**RESPONSE TO REQUEST FOR ADDITIONAL INFORMATION
SSD-11429726 – EDEN STREET COMMUNITIES PLUS**

This letter has been prepared by Ethos Urban on behalf of Arncliffe Eden Property Pty Ltd in response to the Request for Additional Information (RFI) issued by the Department of Planning and Environment (DPE) for SSD-11429726 dated 4 April 2022, as well as additional requests for clarification received by email. This letter should be read with reference to the following appended documentation:

20-171-F01-V1

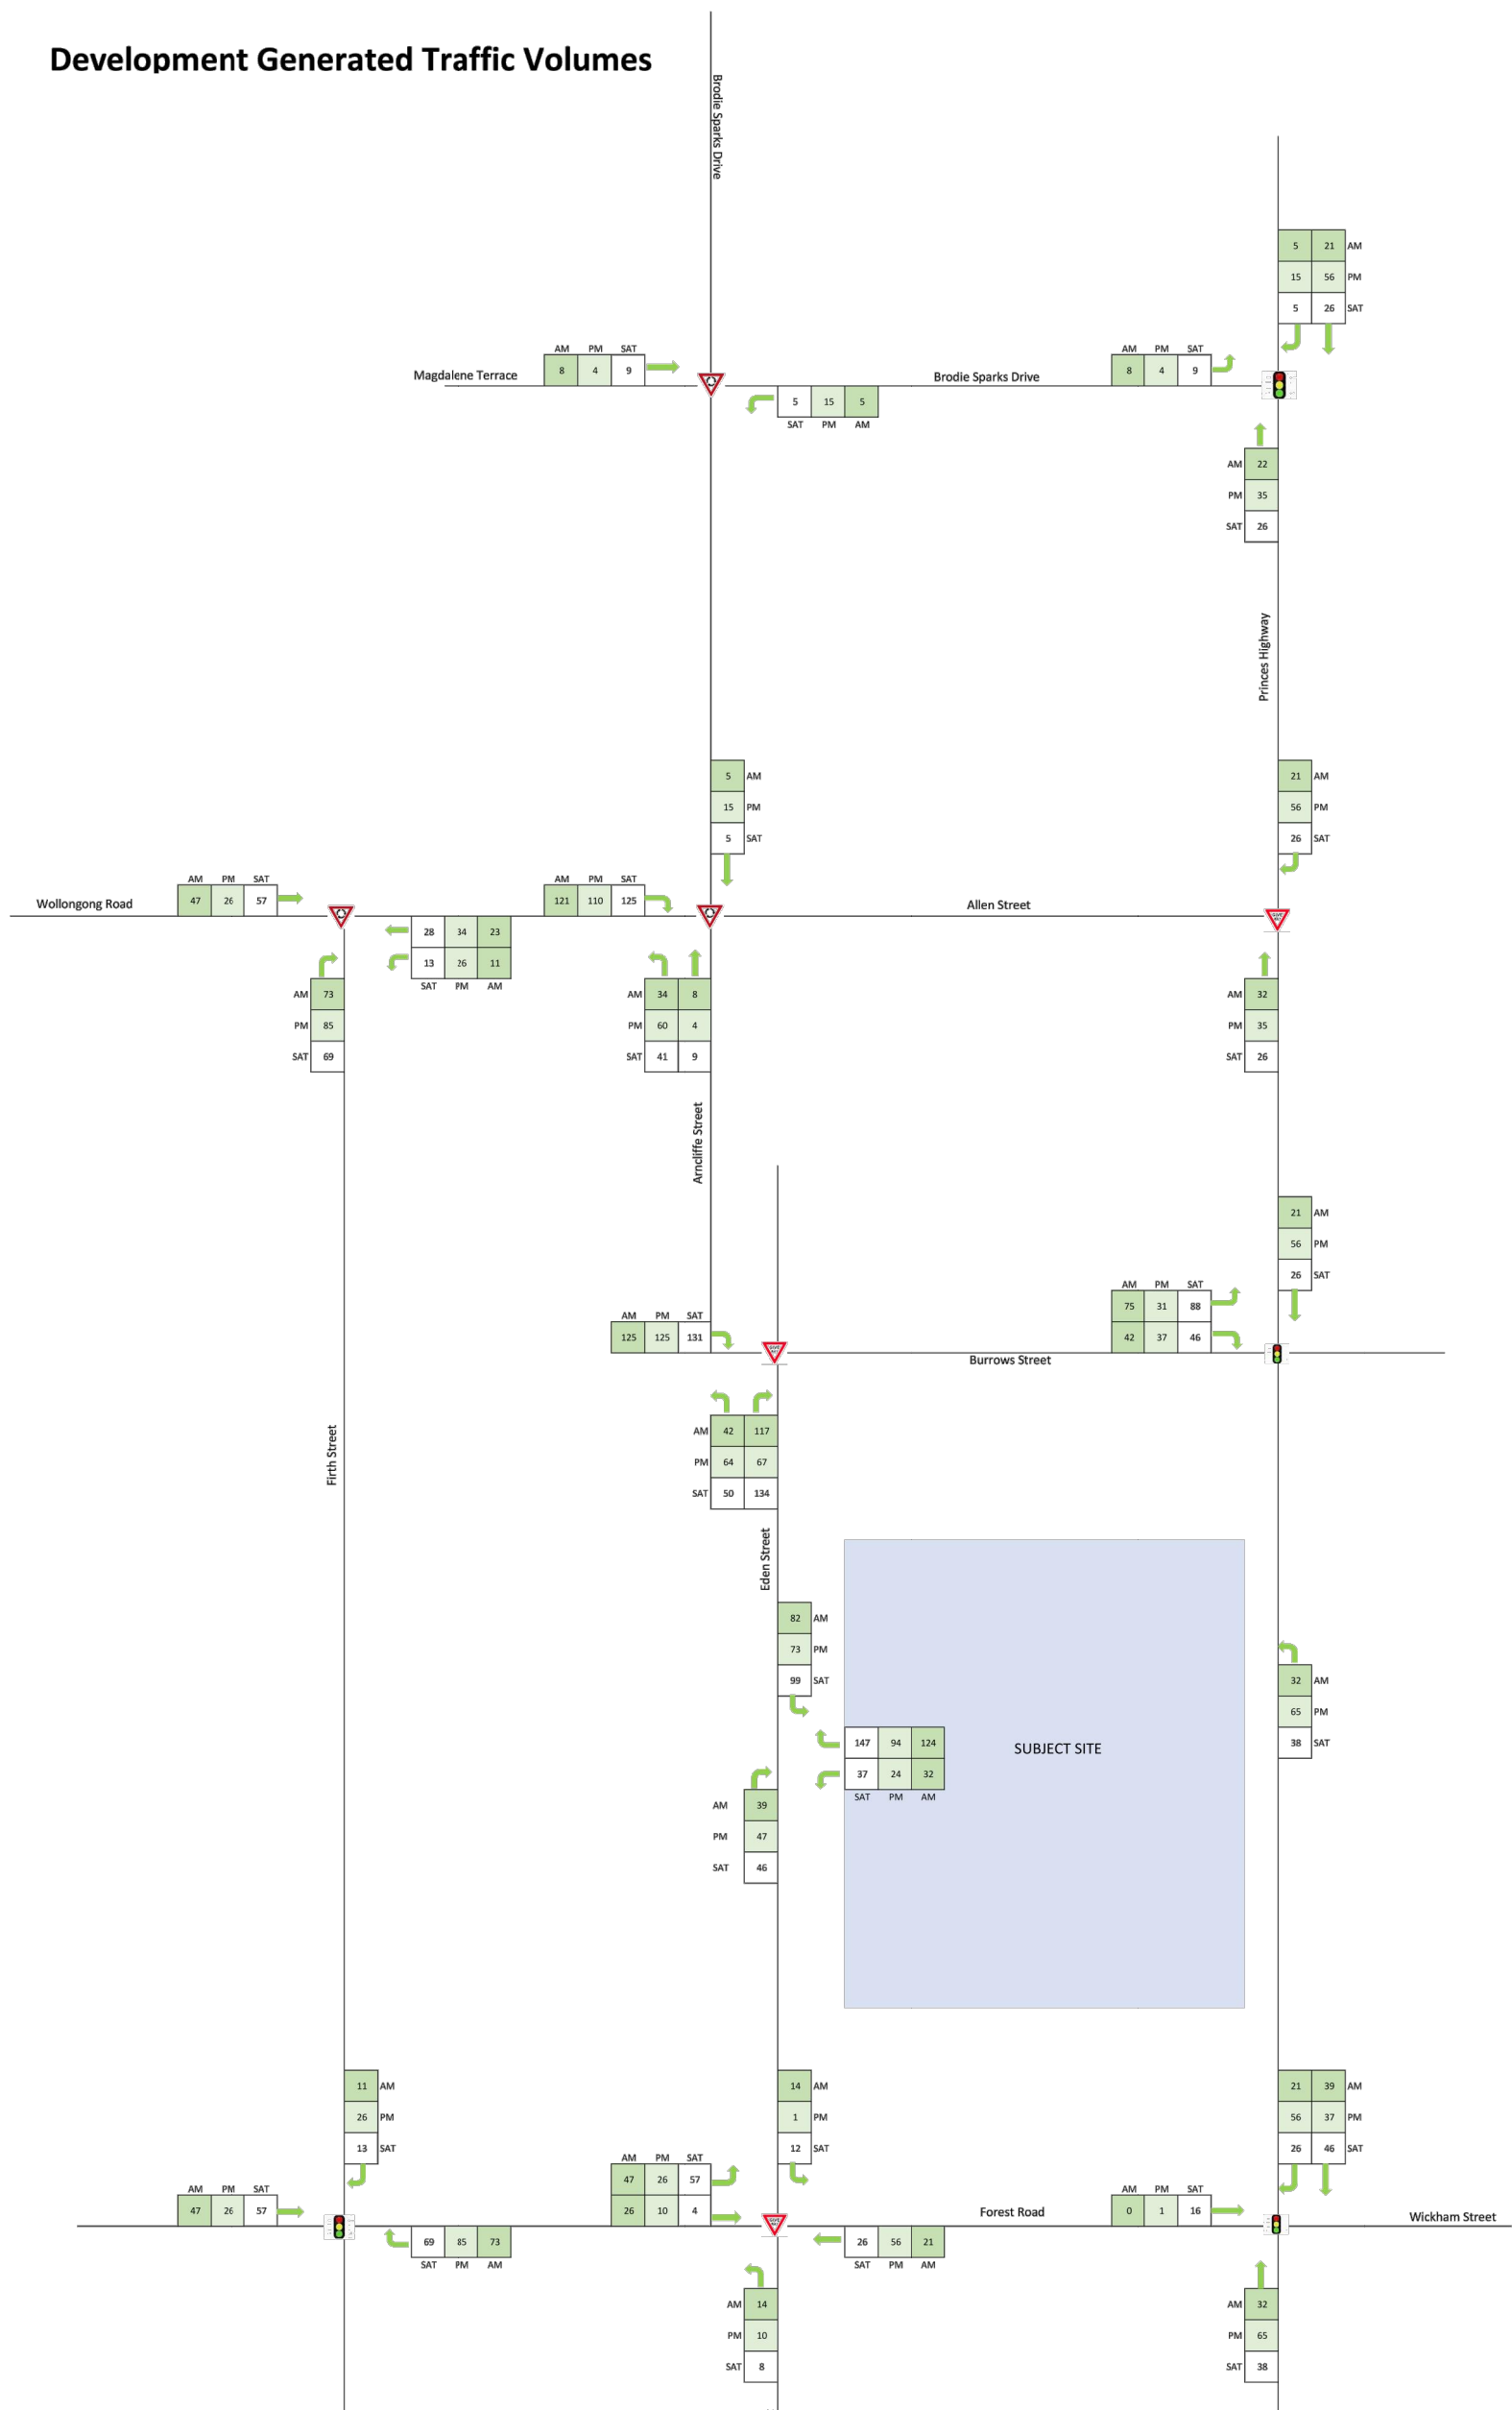
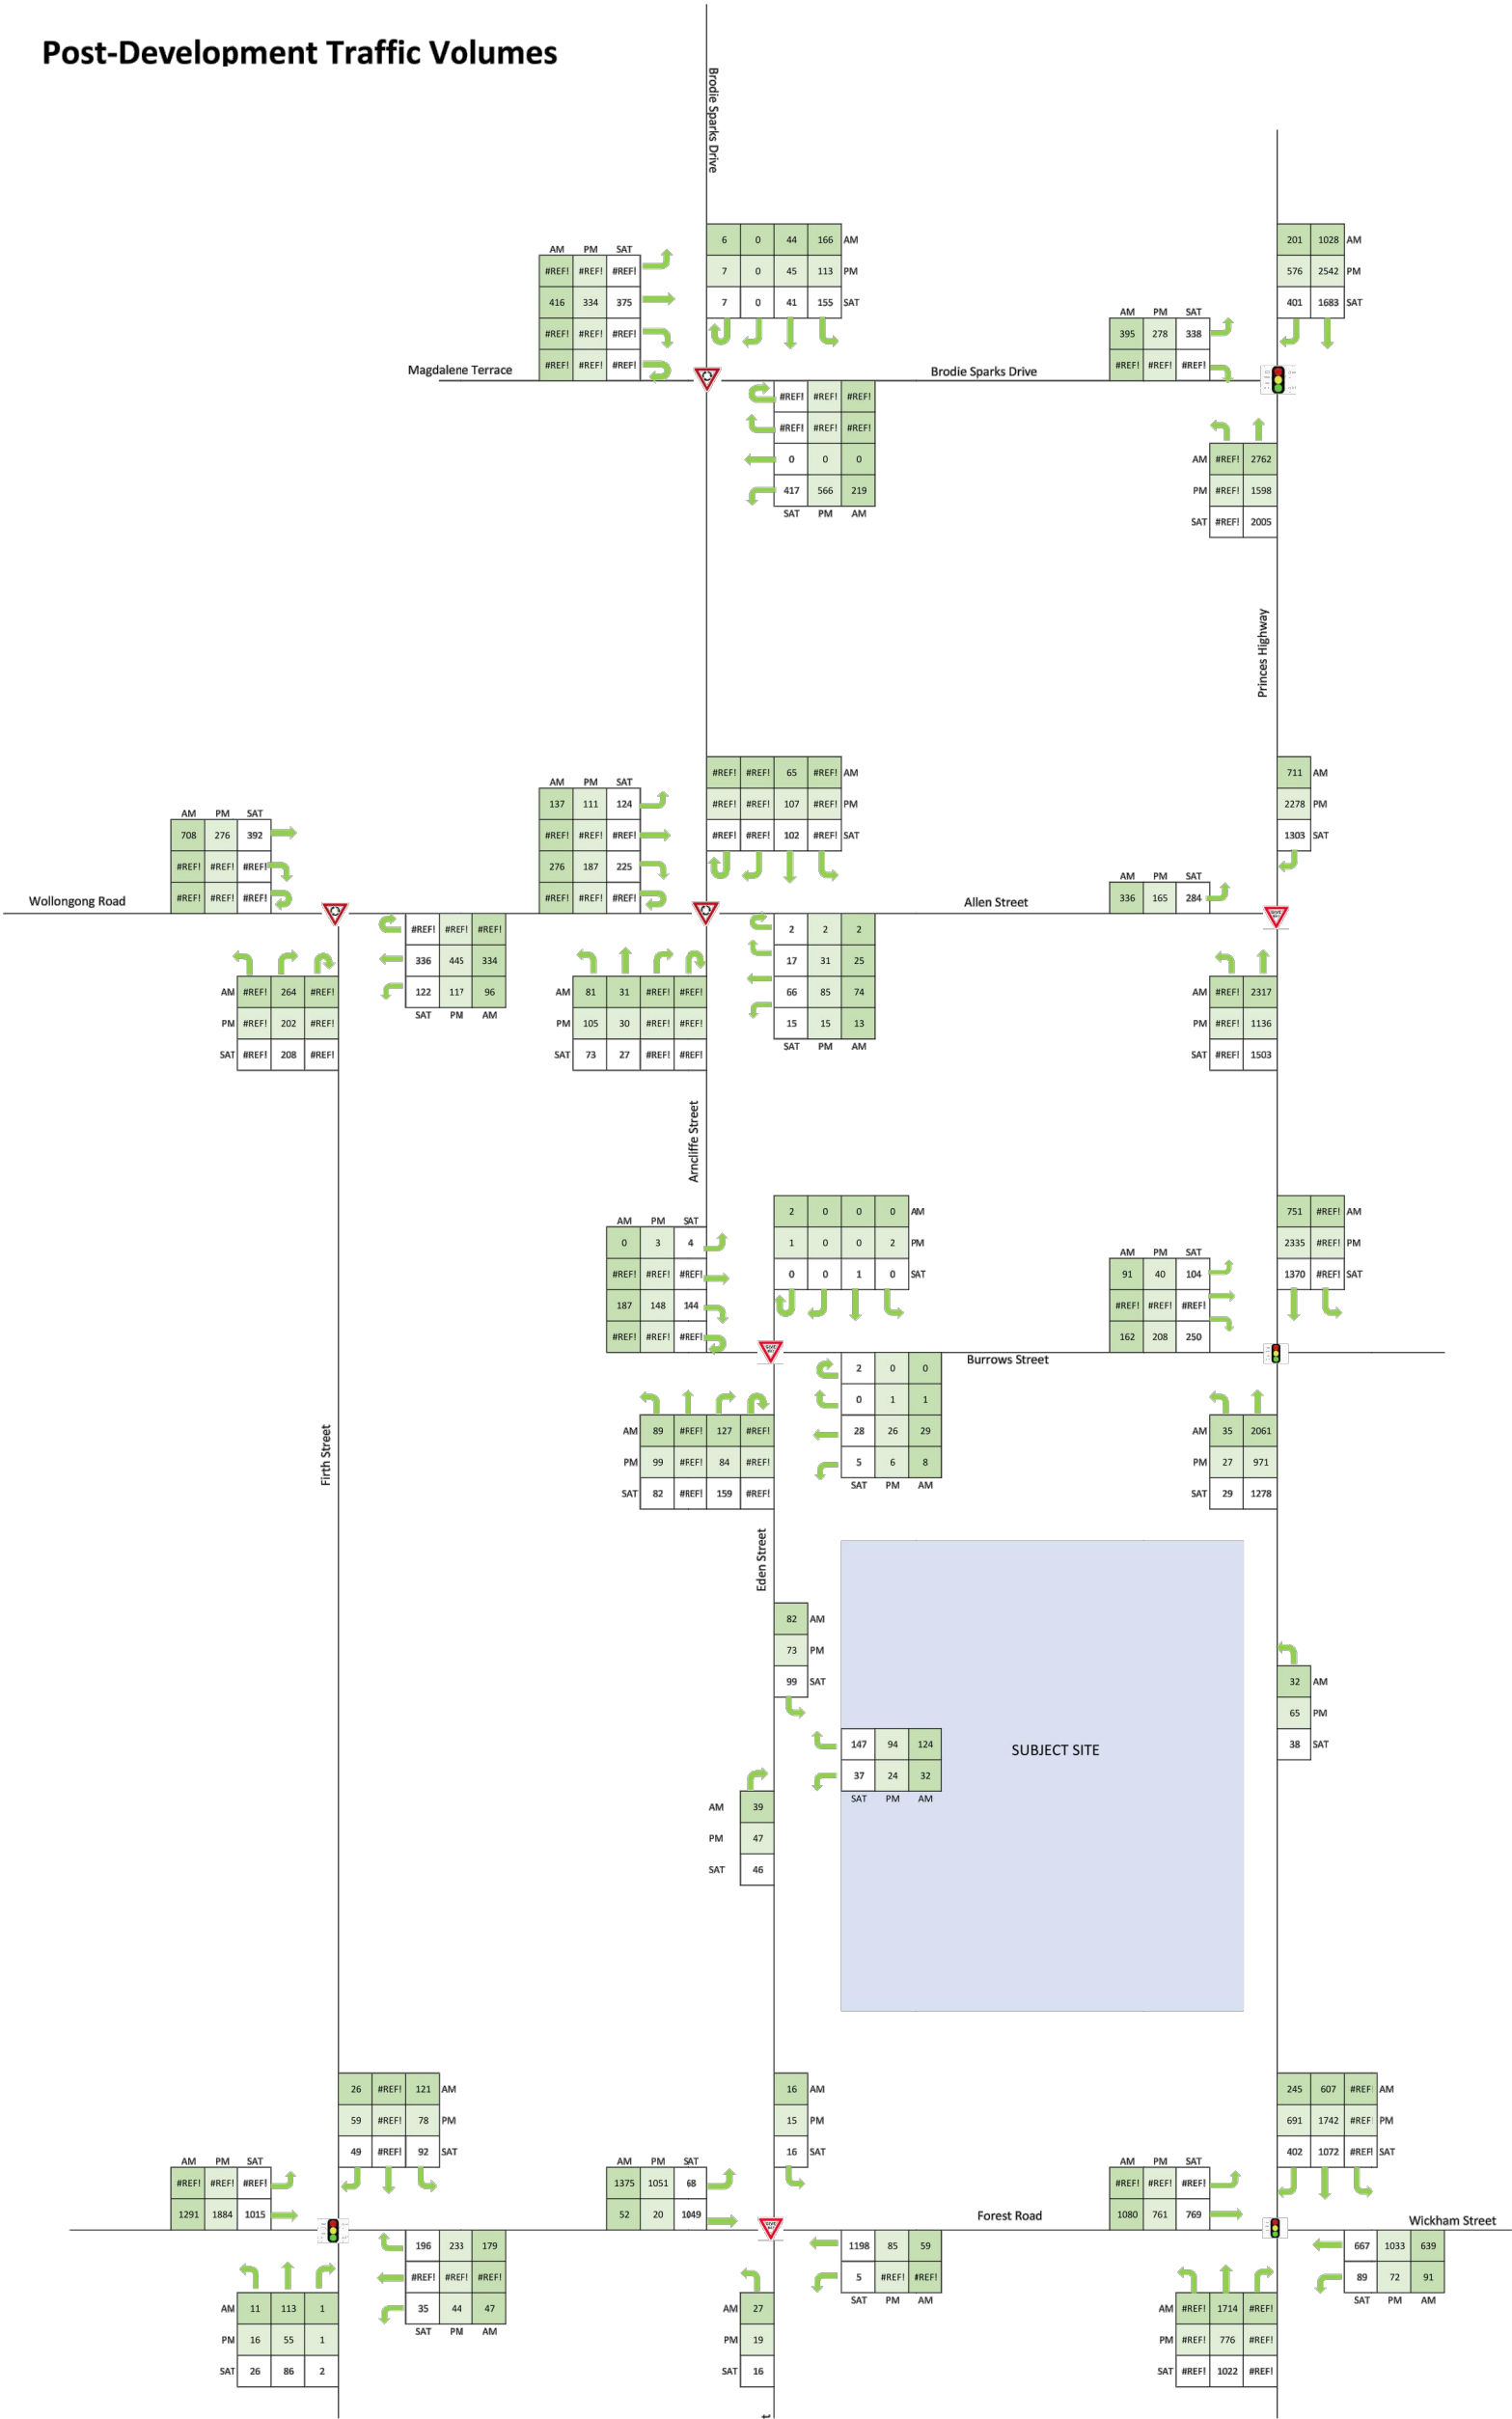
<ul style="list-style-type: none"> EES group comments of 24 February 	<p>A detailed response to comments raised by the EES Group have been provided by Group GSA at Attachment B. The response confirms that Tree 109 is to be retained and protected as consistent with the advice of the Birds Tree Consulting Arborist Report which was submitted as Appendix H of the RTS dated 8 February 2022.</p>
<p>Please also correct the errors within Attachment D to confirm the combined vehicle trips.</p>	<p>Amended Intersection and Route Diagrams have been prepared by Stanbury Traffic Planning at Attachment C rectifying errors in the submitted documentation.</p>
